RE: **Lot 10 Block 9 Unit 22, S.A.D. 228**
6401 Petirrojo Rd. NW
Grading and Drainage Plan
Engineers Stamp Date 5-15-17 (D10D003Q10)

Based upon the information provided in your submittal received 5/16/17, this plan is approved for Grading Permit. Please be advised that, before the building permit can be issued a PAD Certification must be completed and the following comments addressed.

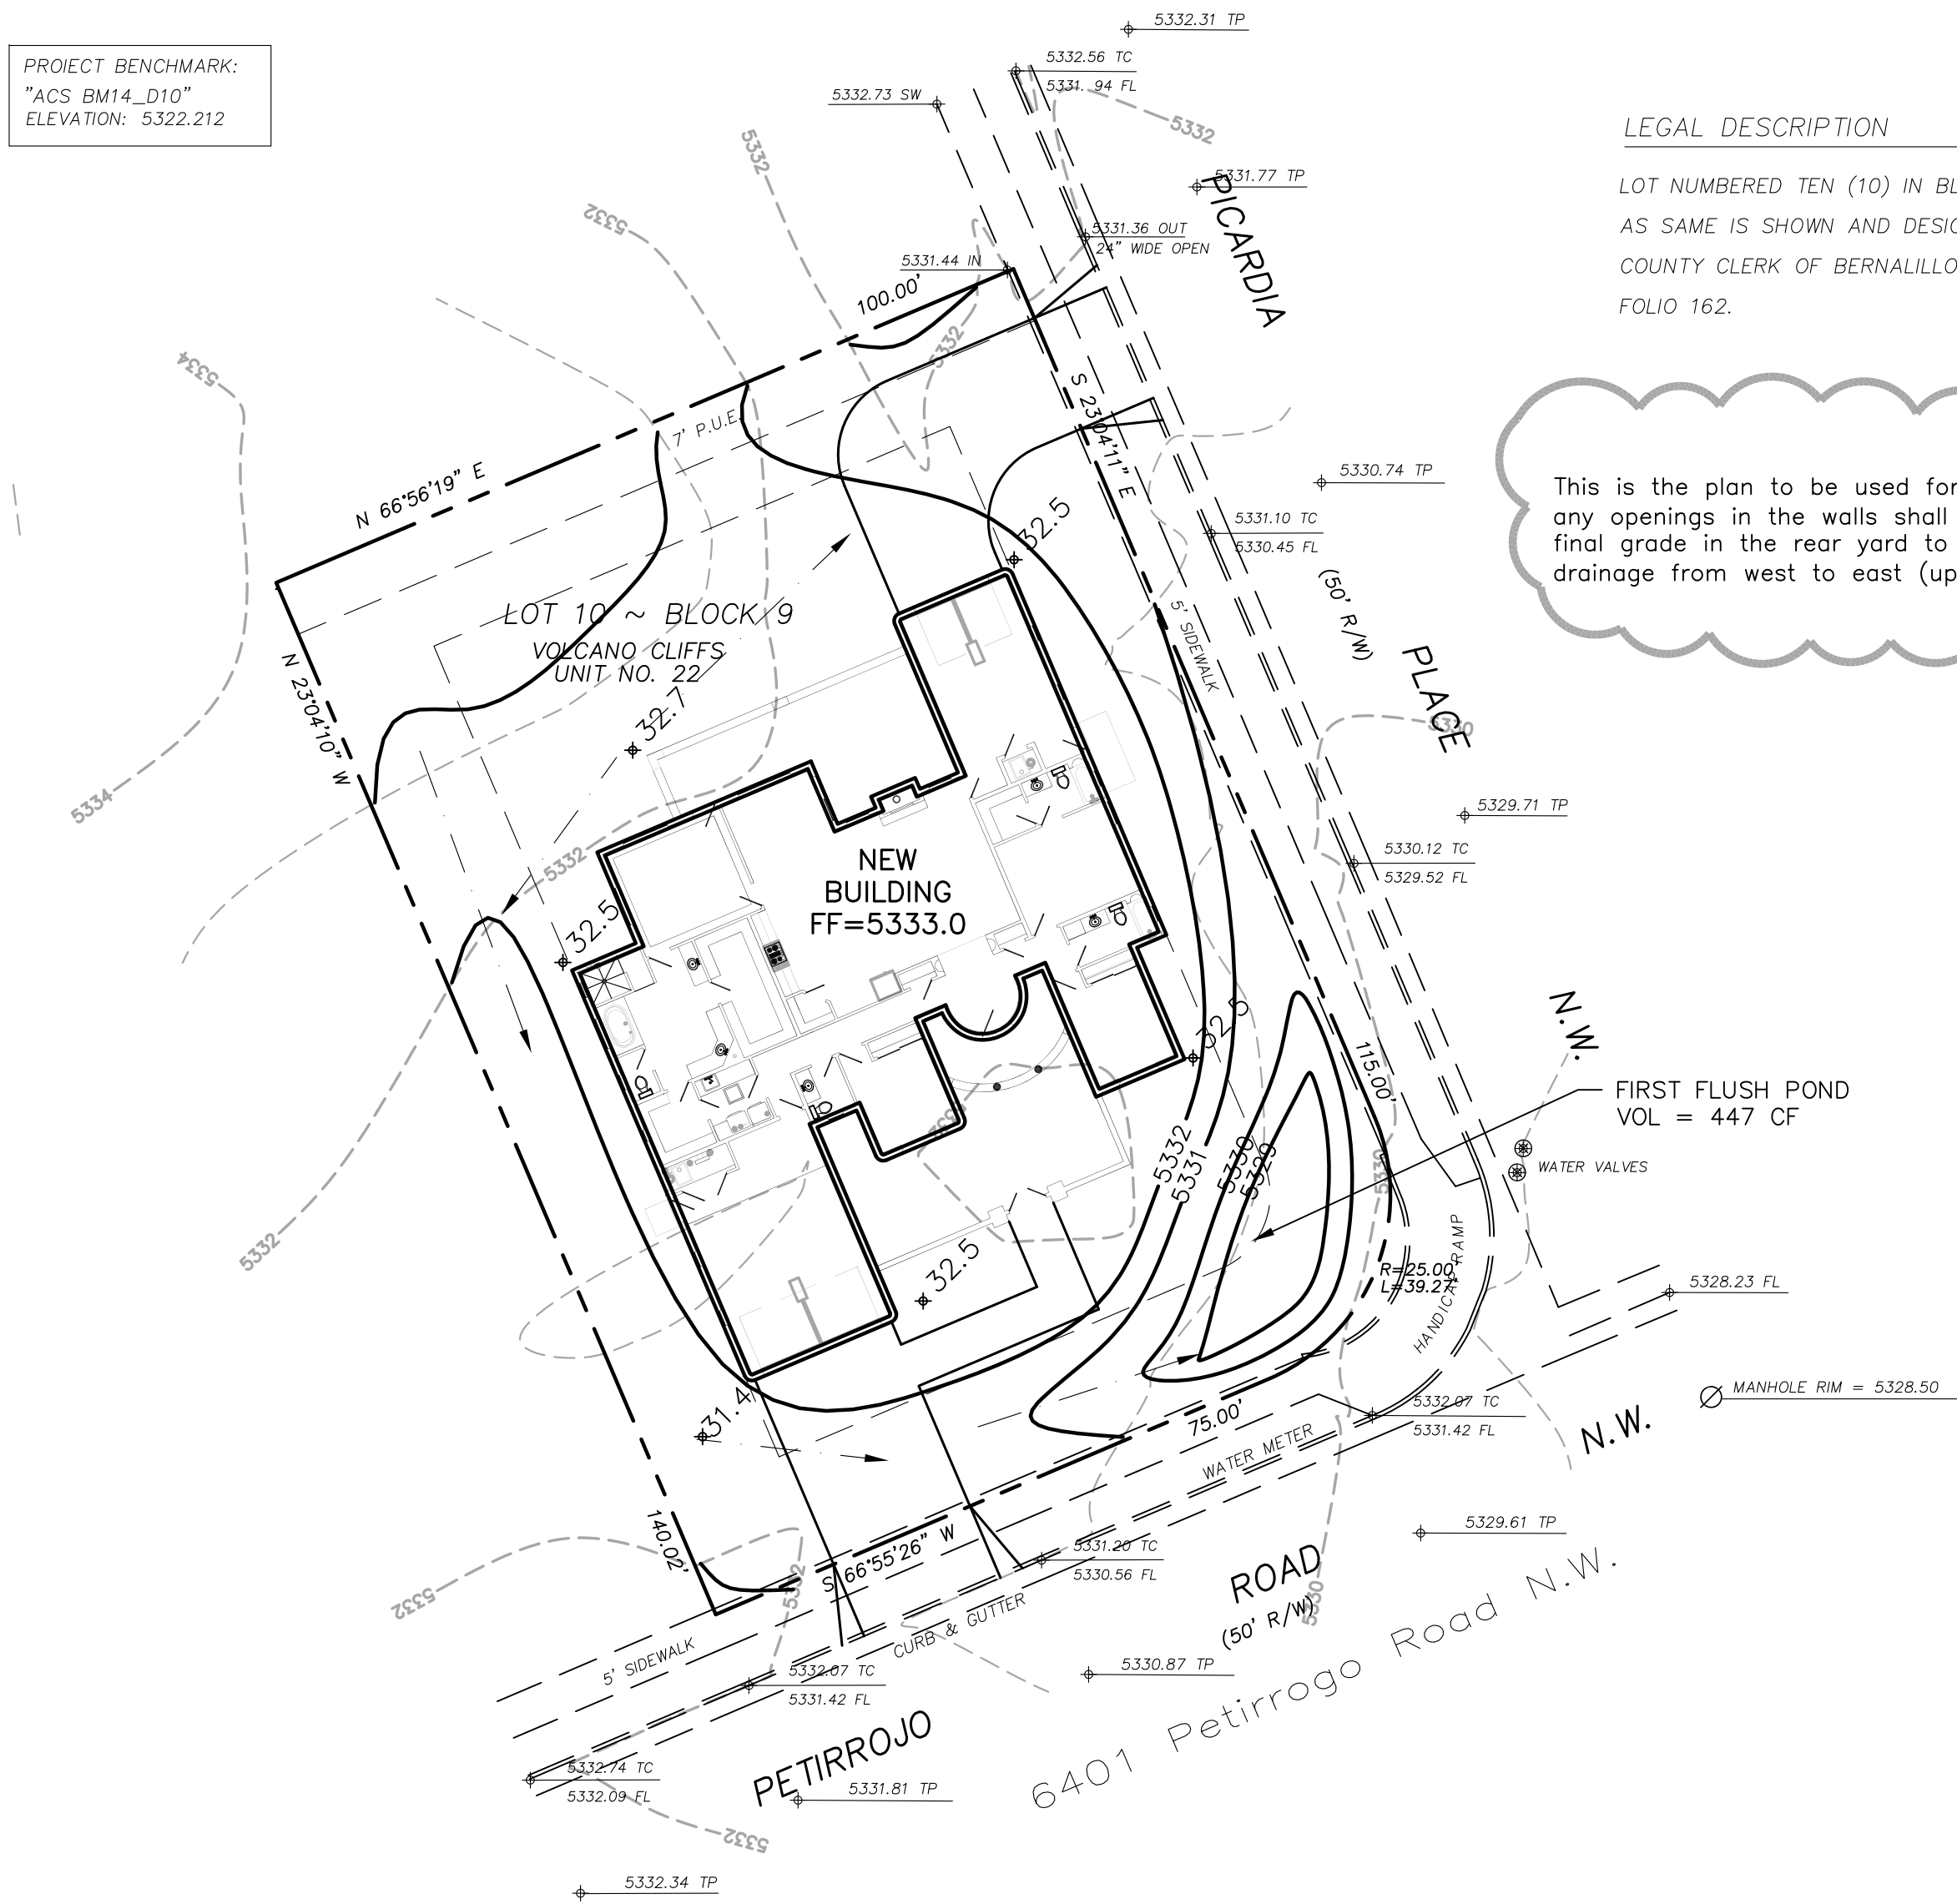
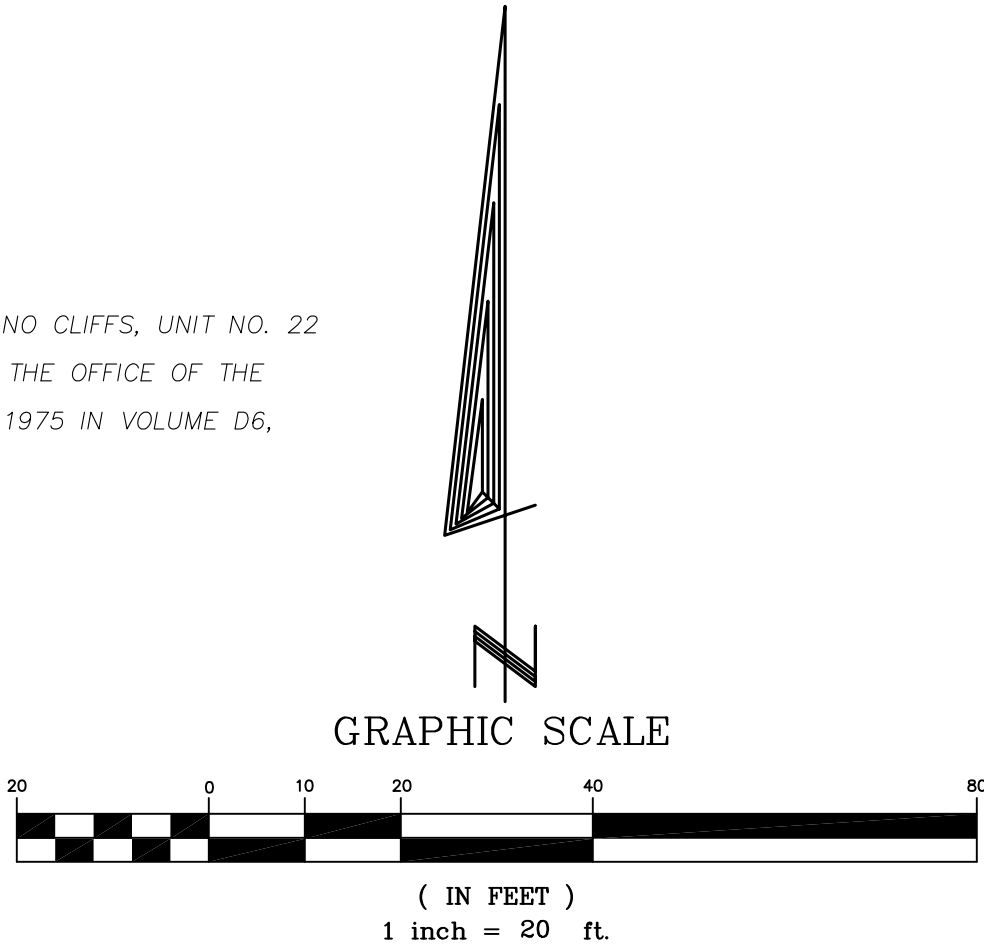
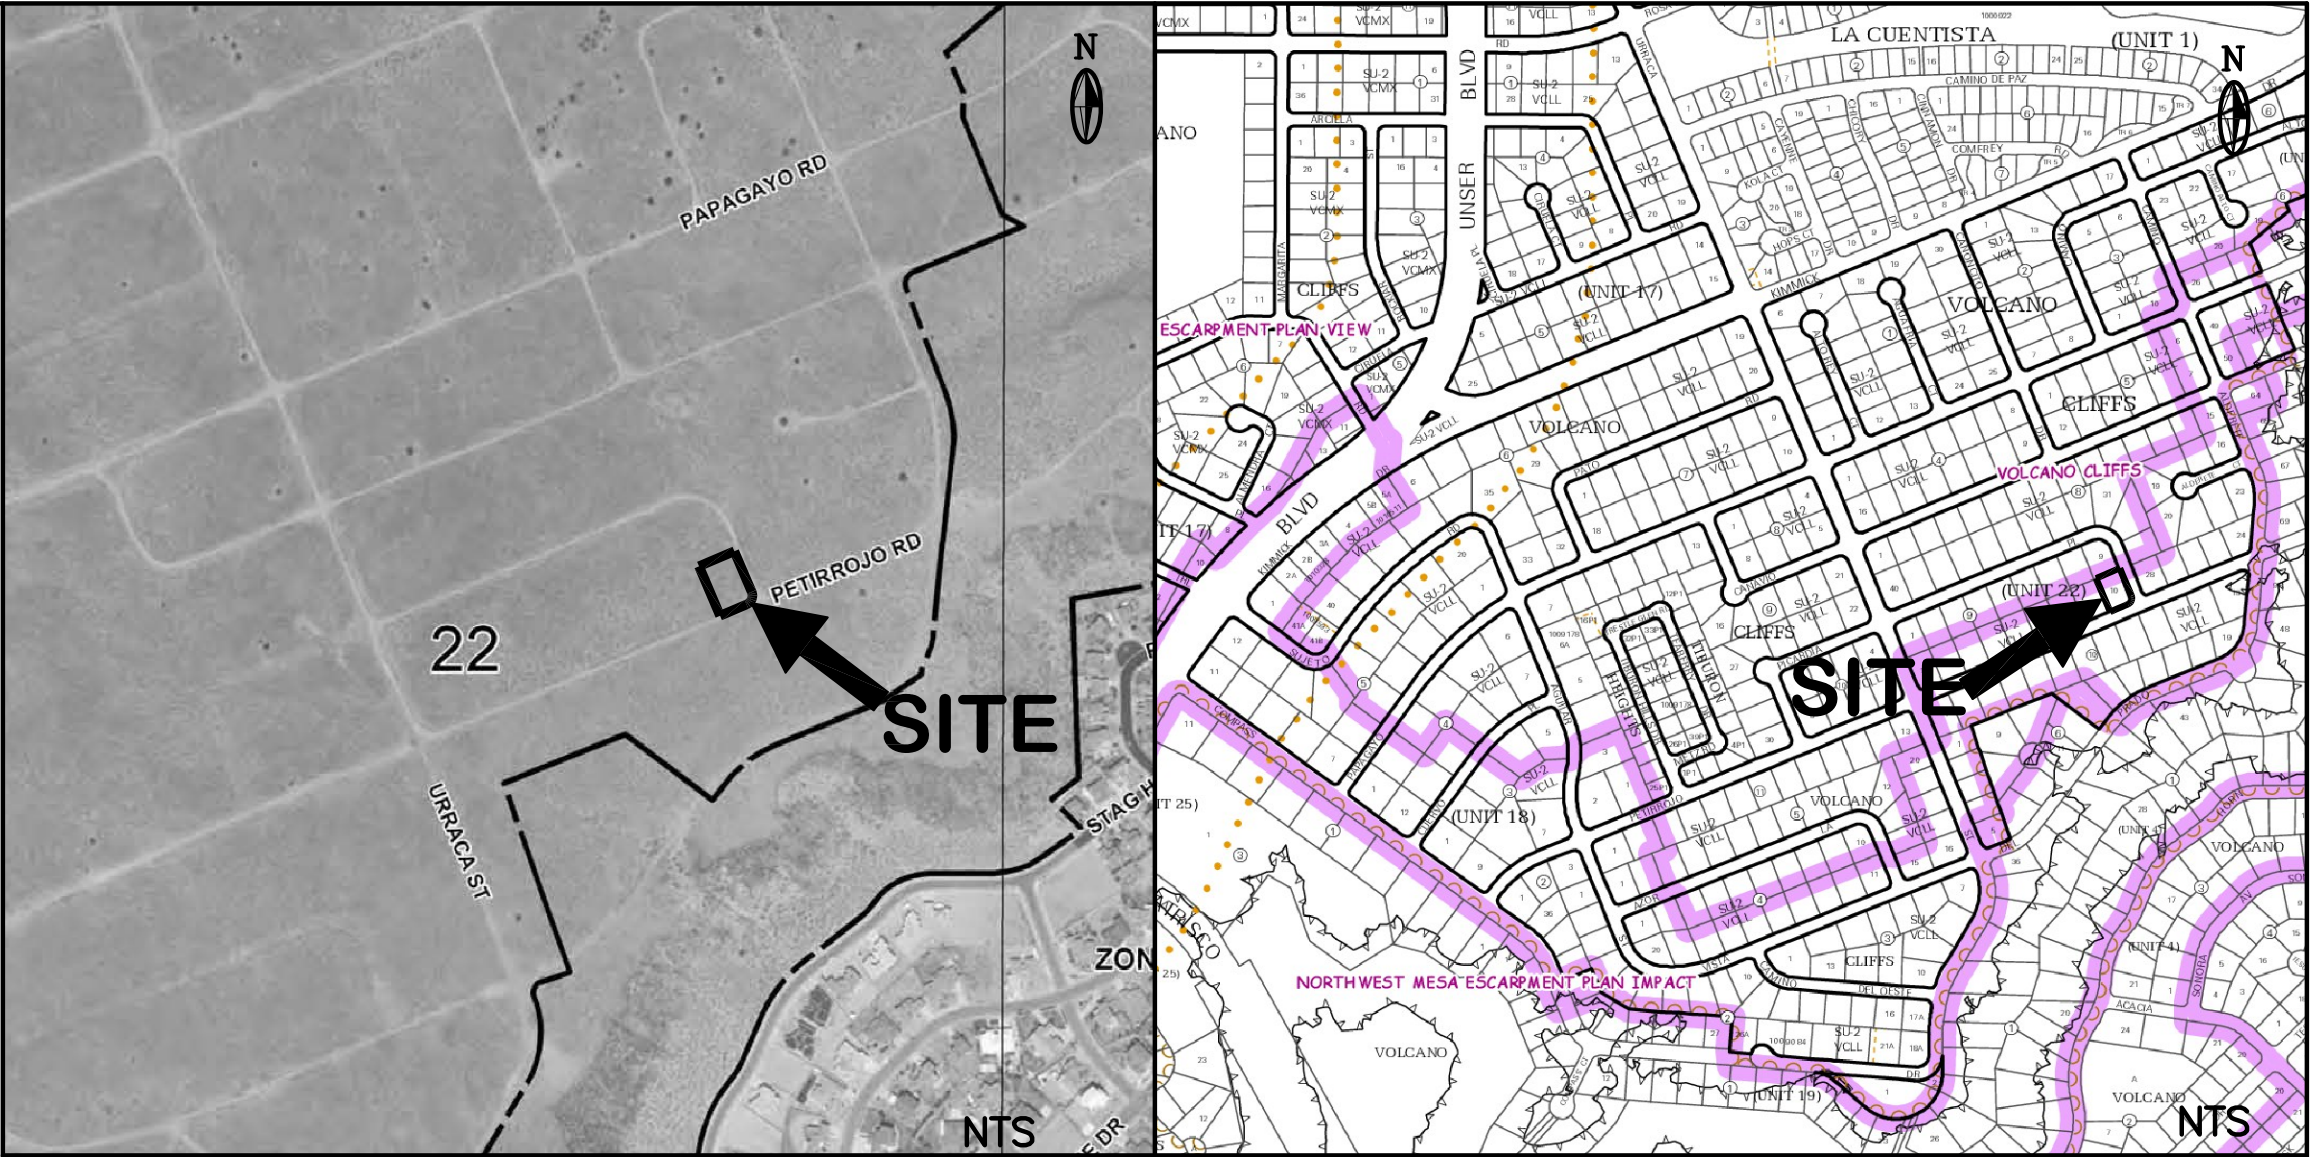
- Provide a note that this is the plan to be used for any garden wall, and that openings in the wall are placed 3" above final grade in the rear yard, to allow for cross lot drainage, heading west to east.
